Application No: BE/37/21/HH
Site Address: 19 South Way Bersted PO21 5HB
Description of works: Removal of 3 No existing lean-to structures, erection of single storey side & rear extension, loft conversion to form new 2nd floor with roof alterations to form gable end with rear dormer projection & detached outbuilding to be used as annexe to existing dwelling.

Thank you for your internet representation made on 23rd April 2021 which has been recorded as an objection with the comments as follows:

PROPOSED DETACHED OUTBUILDING AT 19, SOUTH WAY, BOGNOR REGIS
FOR MR.O.SAPOZHNYK.

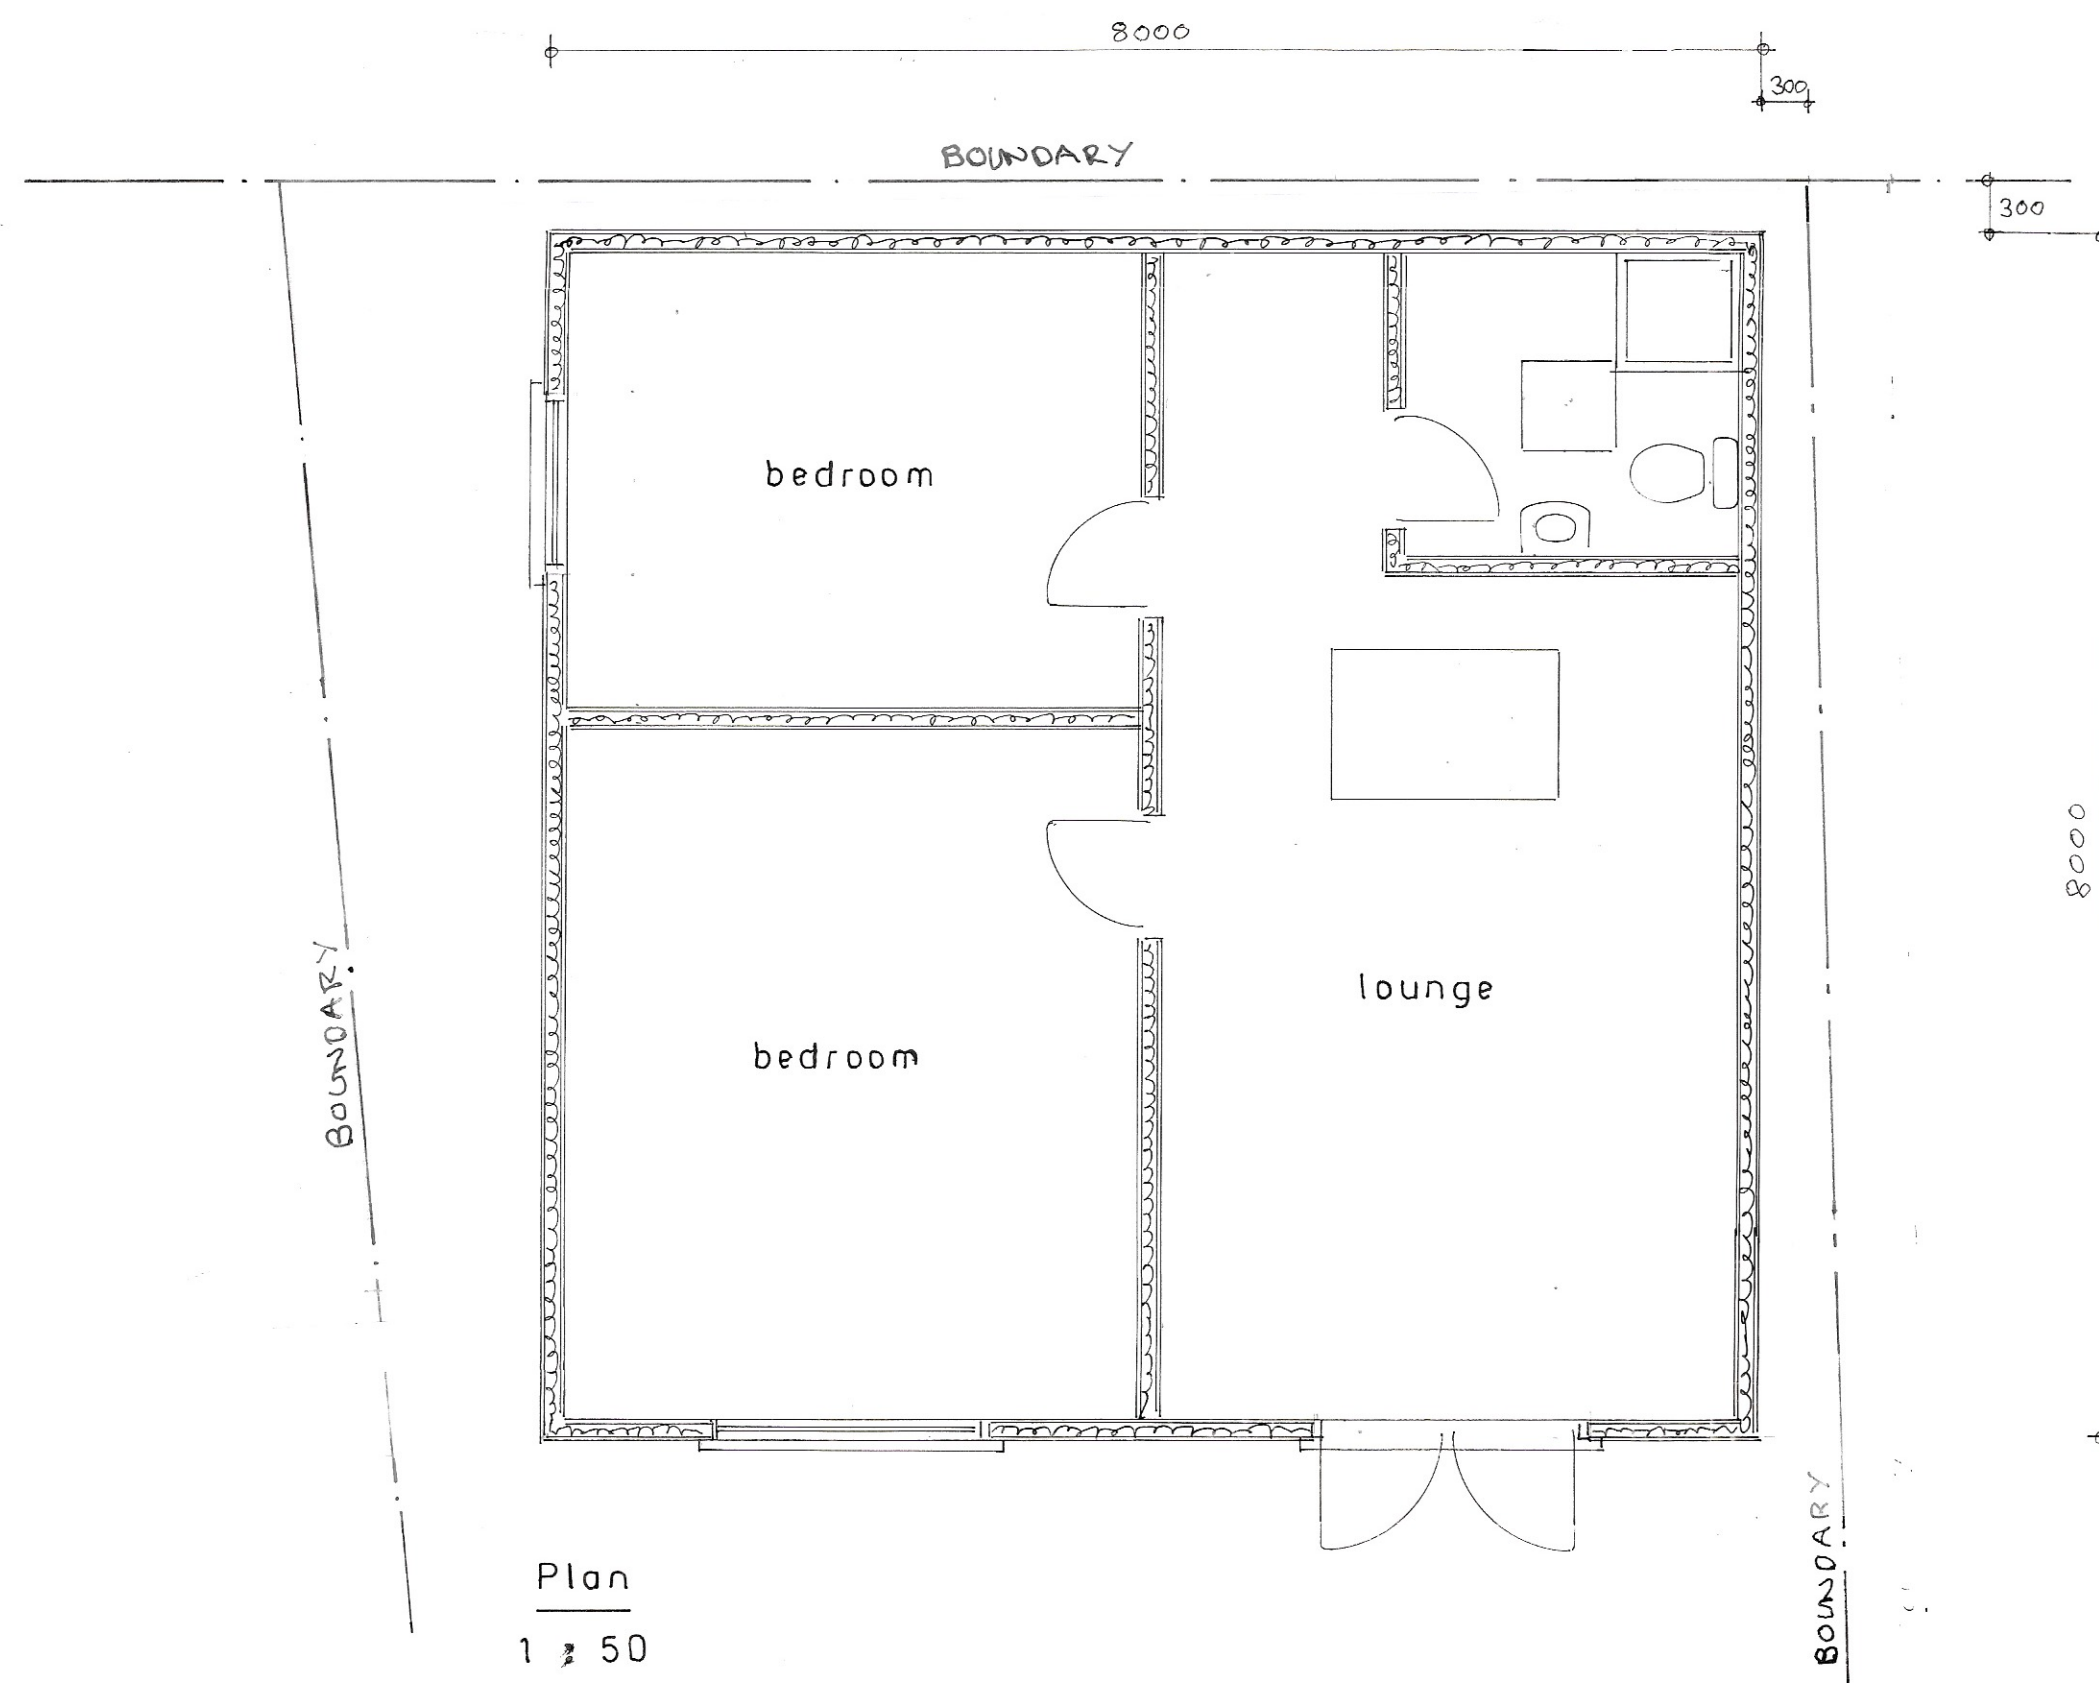
The plans would create an uncharacteristically large house for the area in which it is situated and the construction of the 'annexe' within the garden appears to dramatically reduce the amenity/garden area for such a large dwelling.
